**KIRKLEES METROPOLITAN COUNCIL
INVESTMENT & REGENERATION SERVICE**

DELEGATED DECISION TO DETERMINE PLANNING APPLICATIONS

Reference No:	2024/62/91451/E
Site Address:	88, Shirley Road, Gomersal, Cleckheaton, BD19 4ND
Description:	Erection of detached dwelling with associated external alterations and erection of front dormers including roof alterations to form first floor accommodation, installation of solar panels and external alterations to 88 Shirley Road
Recommending Officer:	Nicole Helliwell

Officer Report

Title: - Proposed Elevations

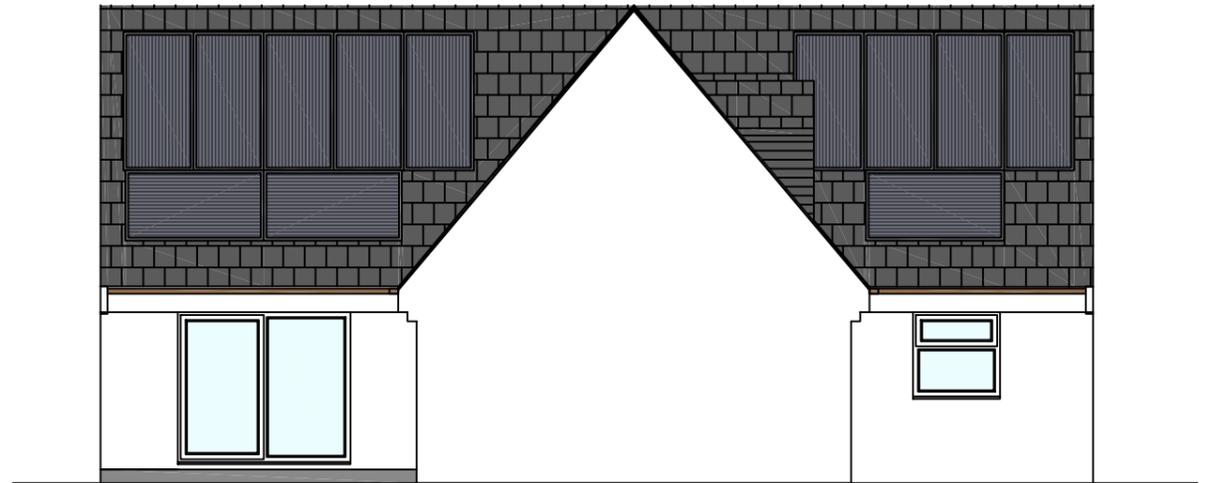
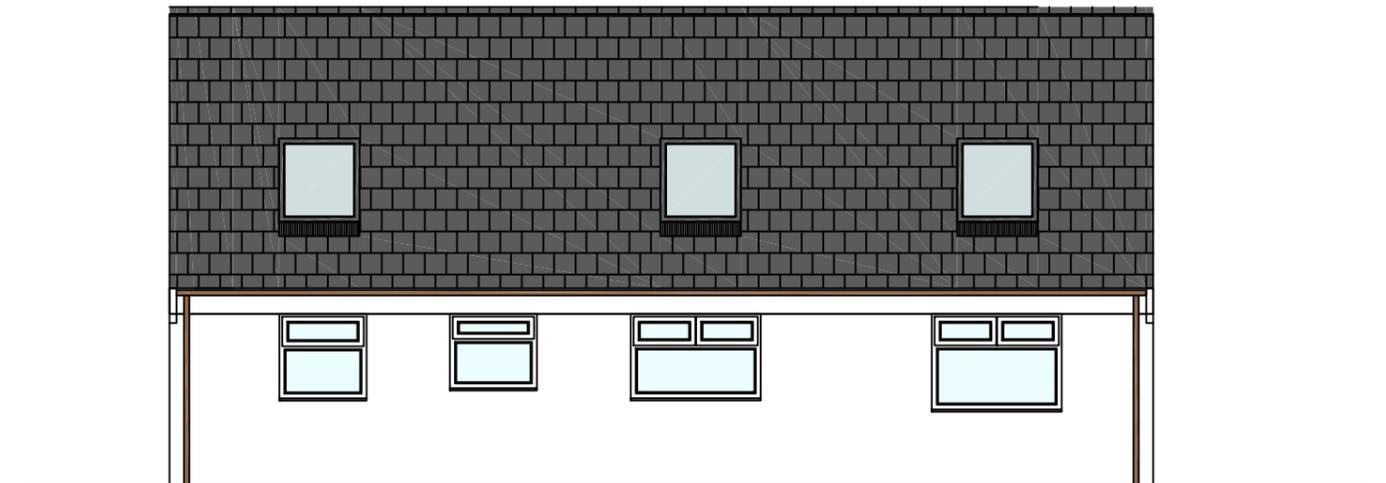
- We would request that the front elevation first floor windows are replaced with Velux rooflights (same as rear & side elevations). This would protect visual amenity and privacy.

Response: *The proposal's potential impact to the neighbouring properties has been assessed within the 'Residential Amenity' section of the report. Furthermore, the proposals impact on the character and appearance of the*

Project: - 88 Shirley Road, Gomersal, BD19 4ND	
Title: - Proposed Plans,Elevations & Sections (New Dwelling)	
Scale: -	1:100
24/04/2024	MH

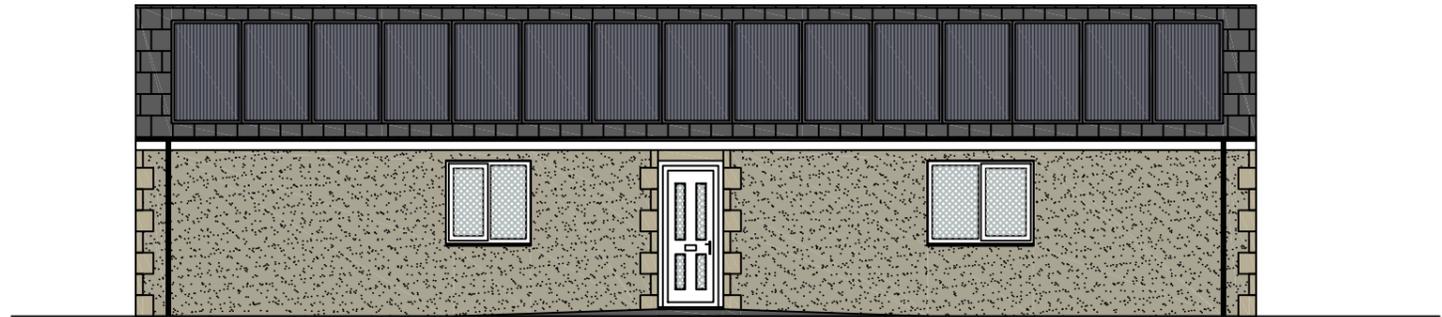
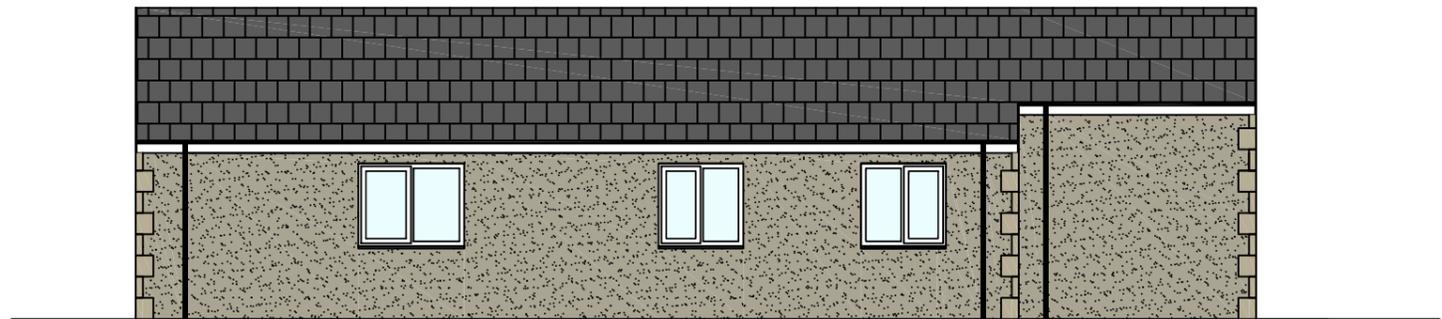
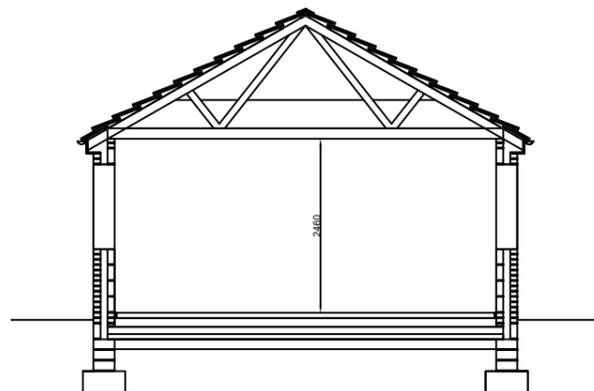
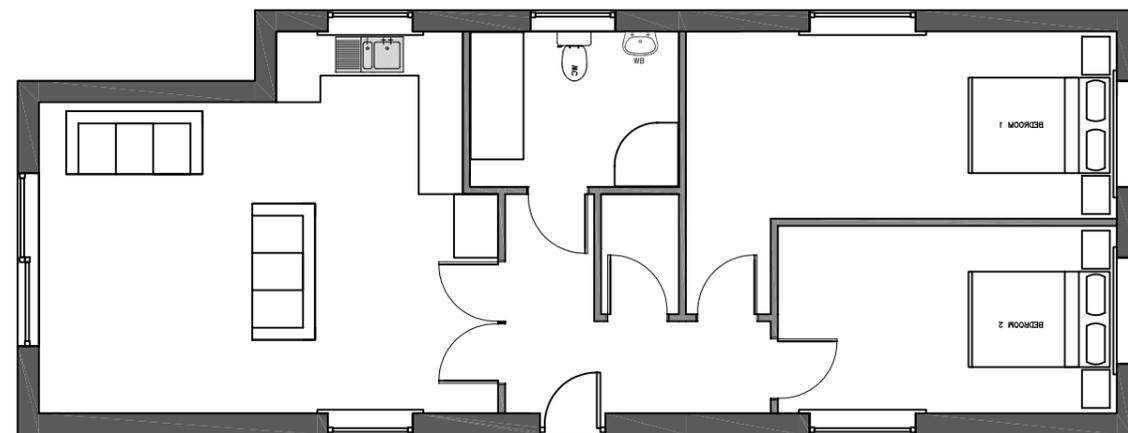
The proposed dwelling, by virtue of its position and the relatively constrained nature of the plot it will be positioned on, will adversely impact on the streetscene by creating a cramped and contrived form of development. The property would appear as a standalone feature that would fail to sympathetically integrate with the neighbouring properties and maintain a sense of openness. Therefore, the proposed development would cause significant harm to the visual amenity of the host dwelling and the wider street scene, and would fail to accord with the aims of Policies LP24(a) of the Kirklees Local Plan, Principles 2 and 5 of the Kirklees Housebuilders Design Guide SPD and Chapter 12 of the National Planning Policy Framework.

1. The proposed dwelling would appear as a standalone feature that would fail to sympathetically integrate with the neighbouring properties and would be out of keeping with the character of the area, to the detriment of visual amenity. The proposal would also introduce an incongruous layout in the street scene which would appear cramped and contrived and would impact upon the open character of the site. The proposal is therefore contrary to the aims of Policies LP24(a) of the Kirklees Local Plan, Principles 2 and 5 of the Kirklees Housebuilders Design Guide SPD and Chapter 12 of the National Planning Policy Framework.

| Title: - Tree Information Plan | |

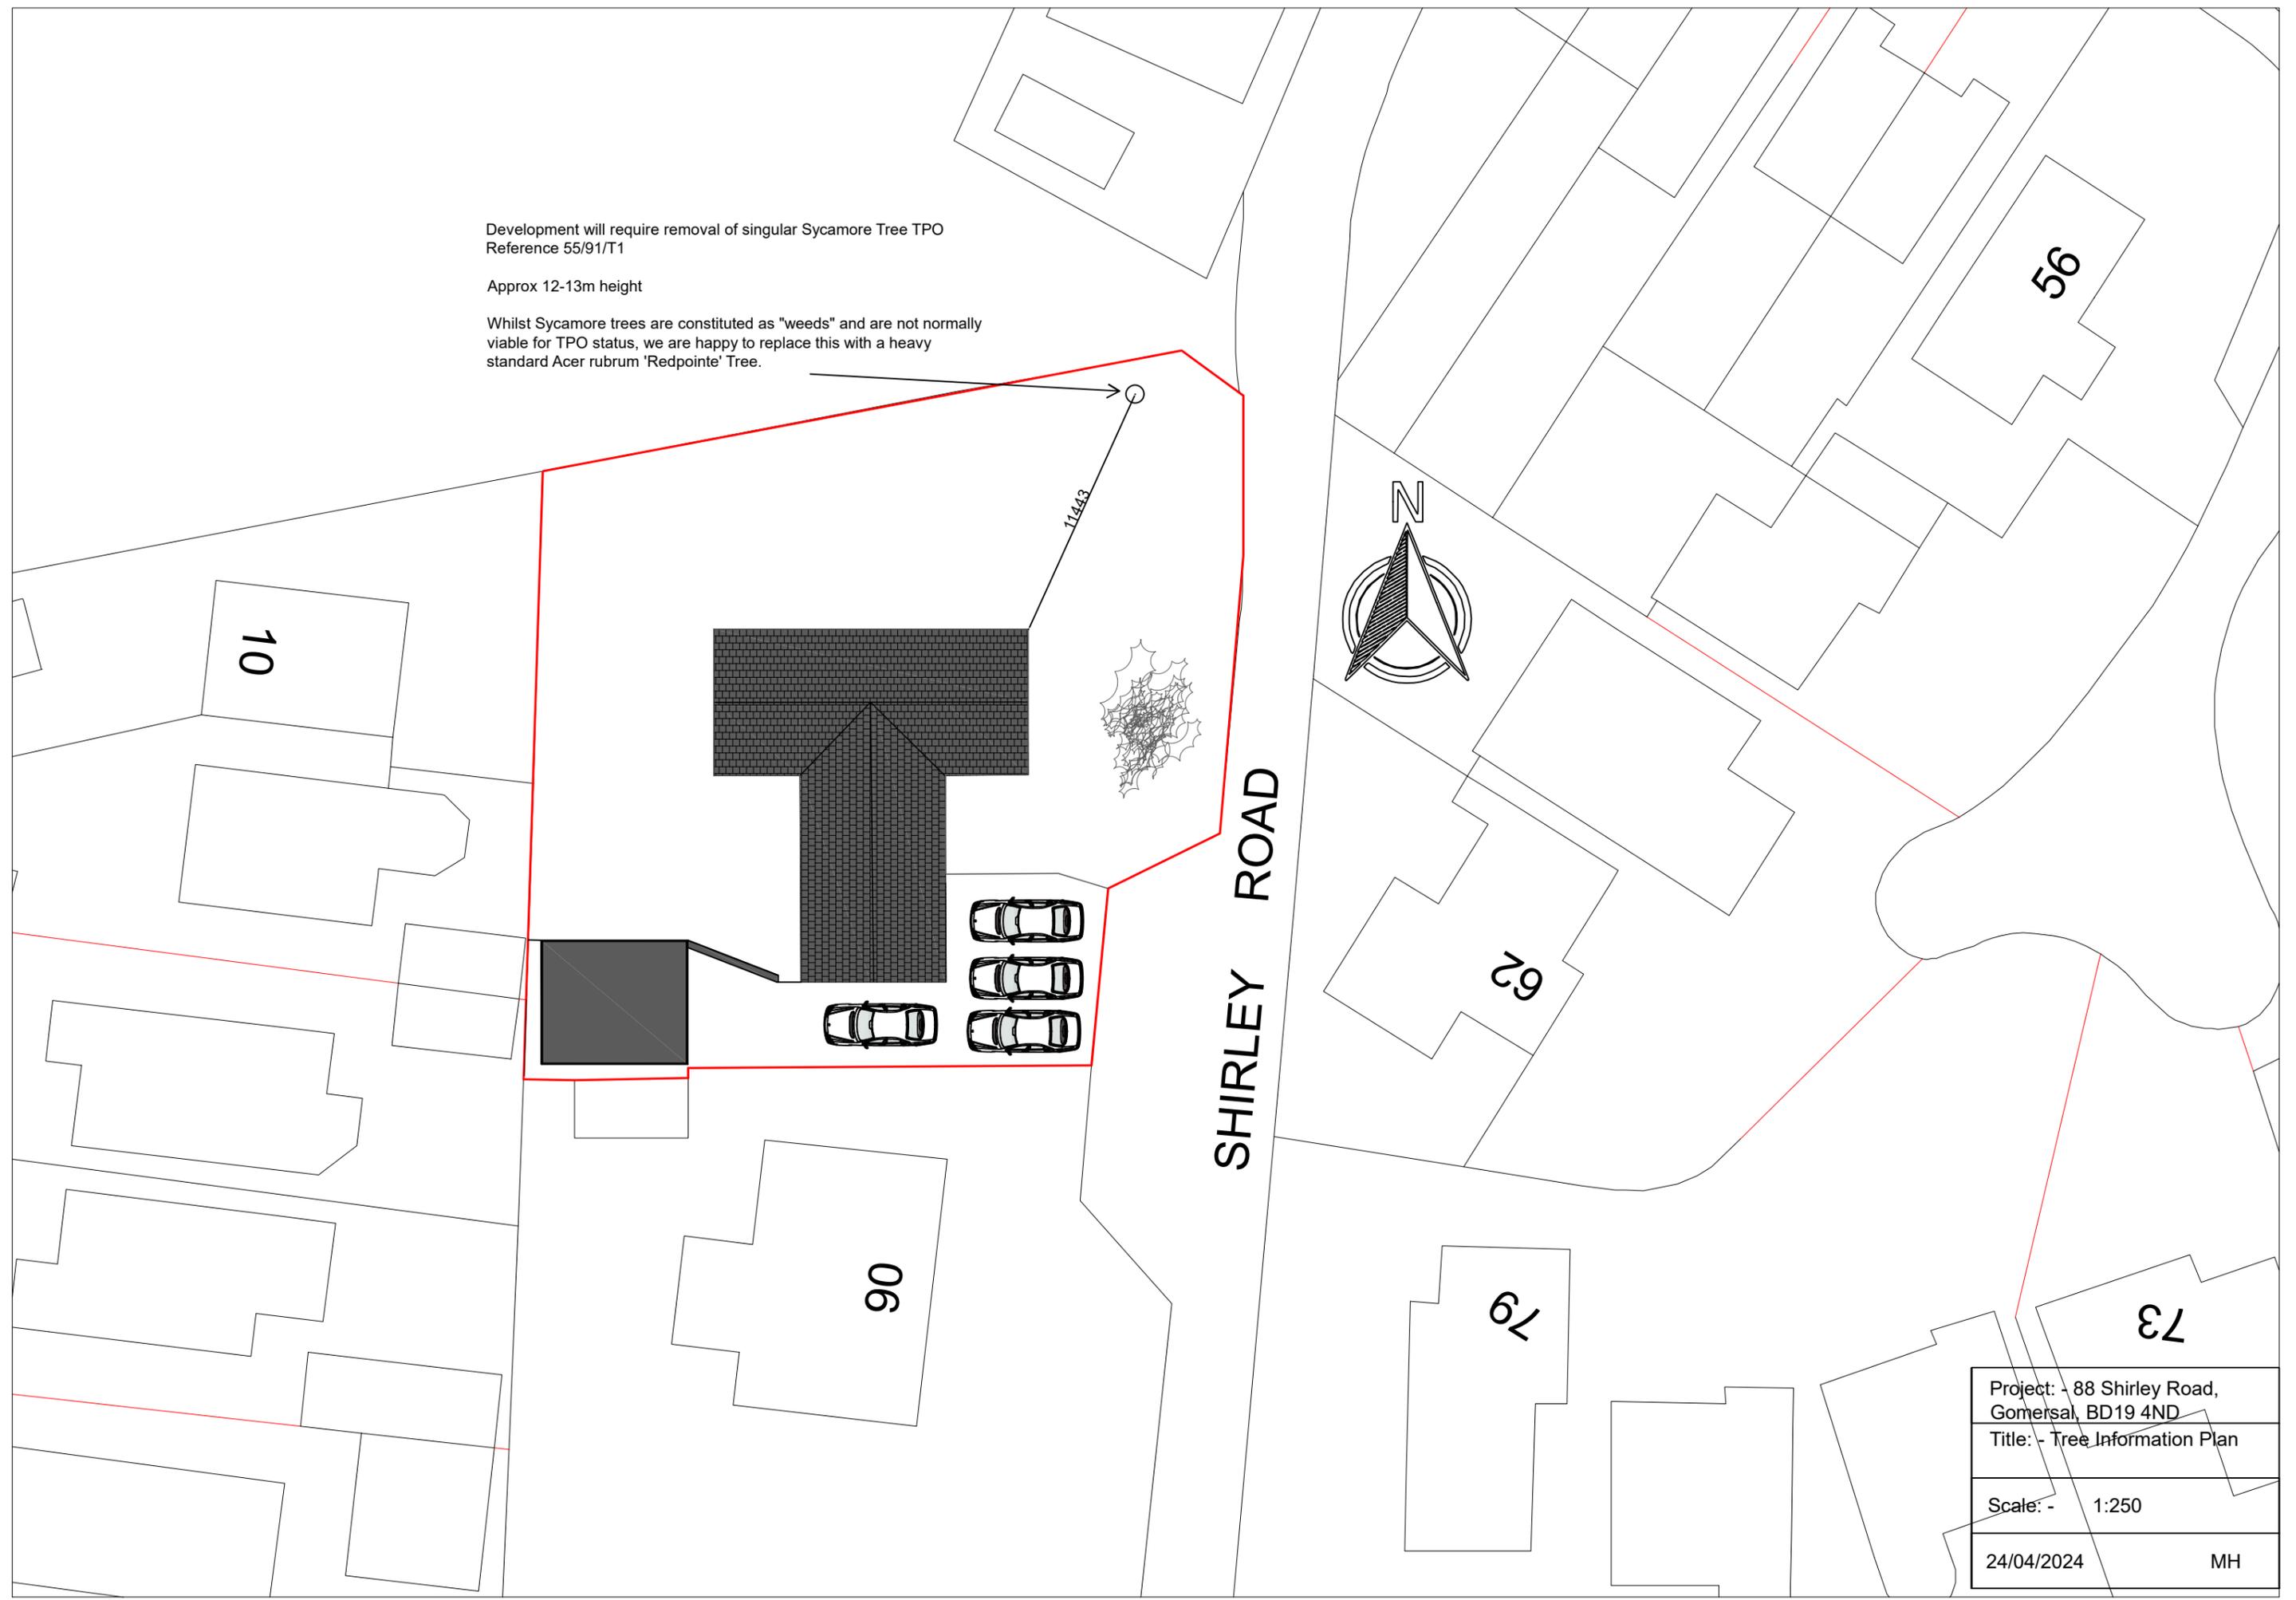
There is a tree which is protected under a Tree preservation order (TPO 55/91) to the north-east of the application site. The proposed works would require the removal of the protected tree purely to facilitate the proposals. Whilst replacement planting is suggested, this would not mitigate the loss of a mature sycamore tree and the amenity value it provides to the wider area. Furthermore, its removal would also have a detrimental effect on the wider landscape. On this basis, there is an objection from a trees perspective as the proposal conflicts with adopted Kirklees local plan Policy 33 and 24 (i).

2. The proposed works would lead to the loss of a protected tree of significant amenity within the application site. To permit the development would be contrary to Policies LP24 and LP33 of the Kirklees Local Plan and Chapters 12 & 15 of the National Planning Policy Framework.
